ITEM 5.1 (a)

Issue/ Objection:
Solar Impact/
Overshadowing

85 Harrington Street
The Rocks
GOLDEN AGE & HANNAS THE ROCKS

RESPONSE TO DoPE
ITEM 5.1 (a)

TITLE
Elevations
West Elevation (Gloucester Street)

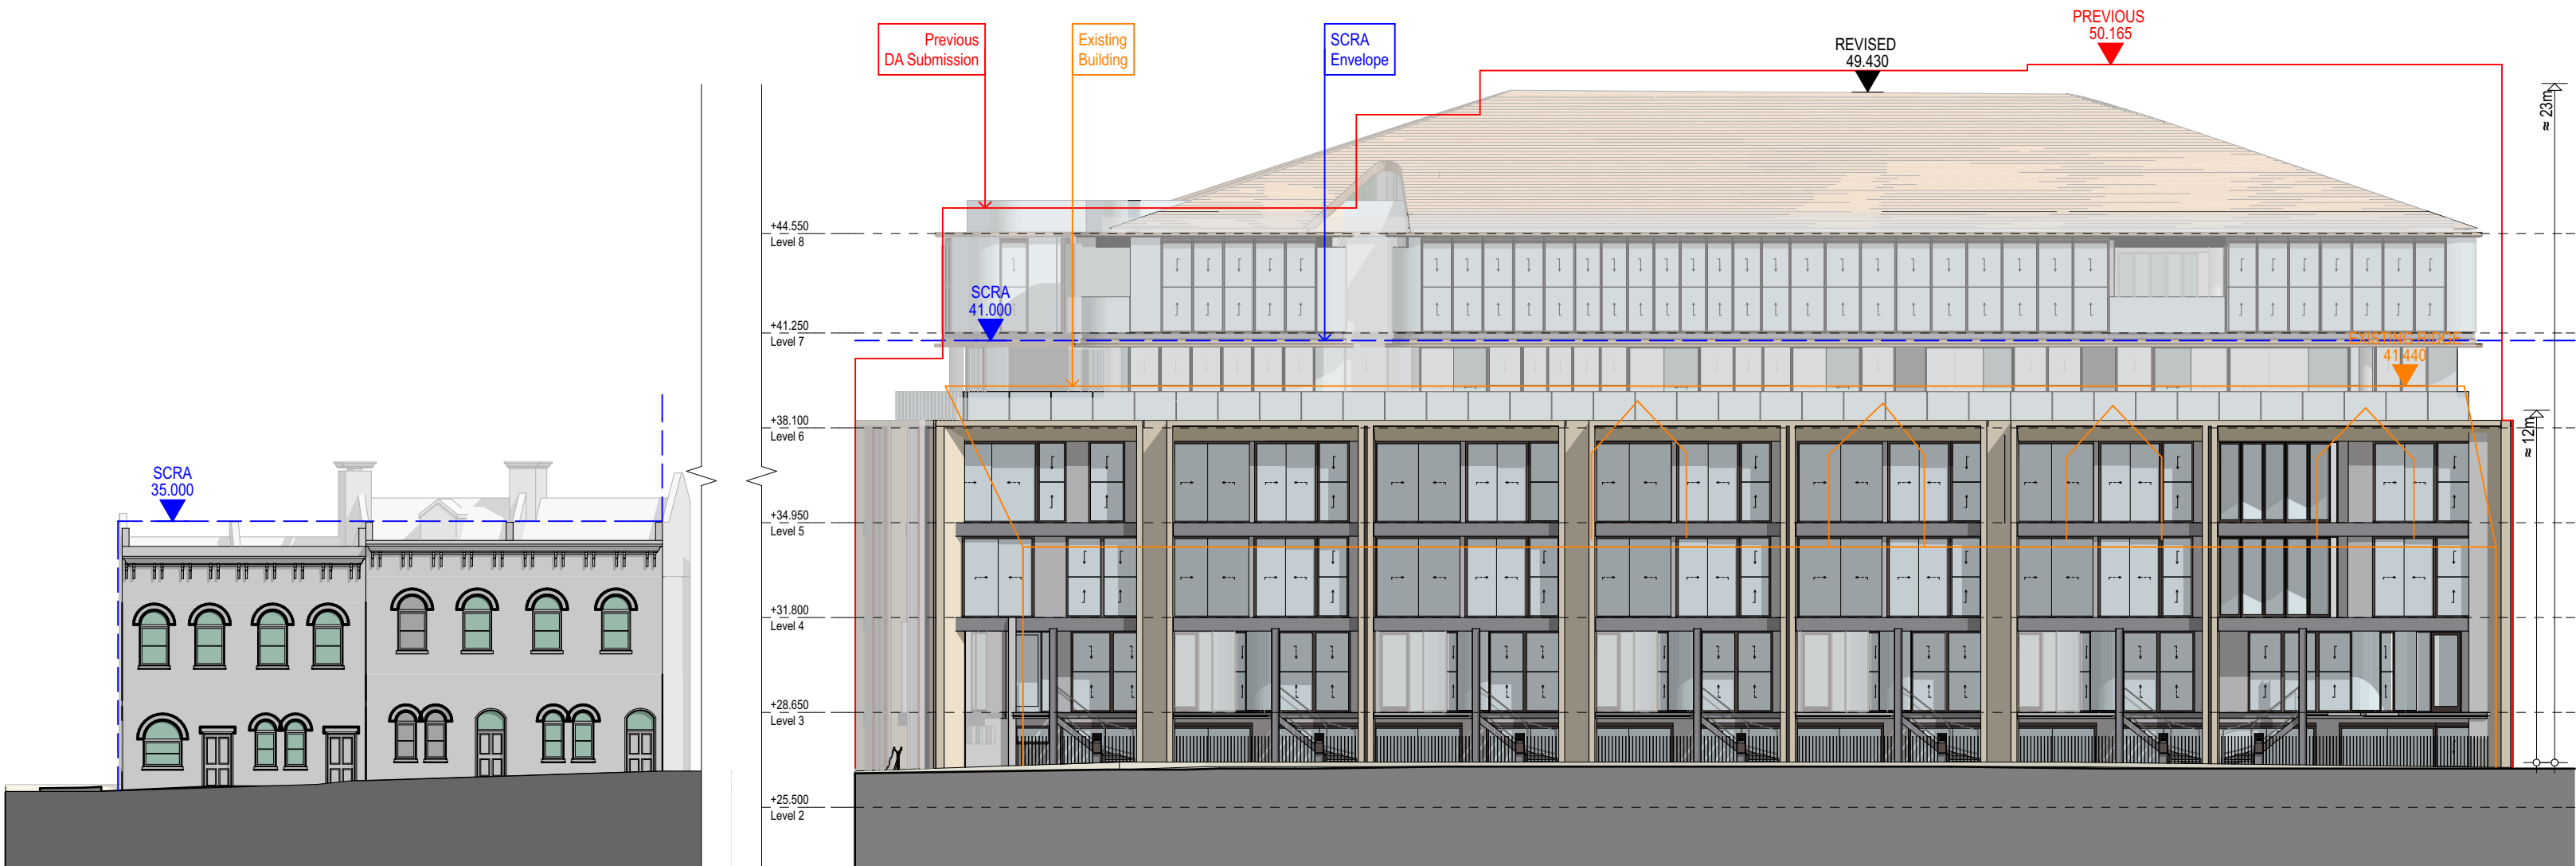
Description:
Revised and enlarged 9am mid-winter elevational shadow diagrams clearly illustrating the extent of overshadowing compared to a SCRA compliant scheme. 9:30am diagrams should be provided if any shadow increase to neighbouring properties in Gloucester Street will occur at 9am

Response
Revised diagrams have been provided showing overshadowing impacts for Gloucester Street. These have been provided at both 9am and 9:30am for both March, June, September 21. The analysis concludes that the development largely improves on a SCRA compliant scheme.
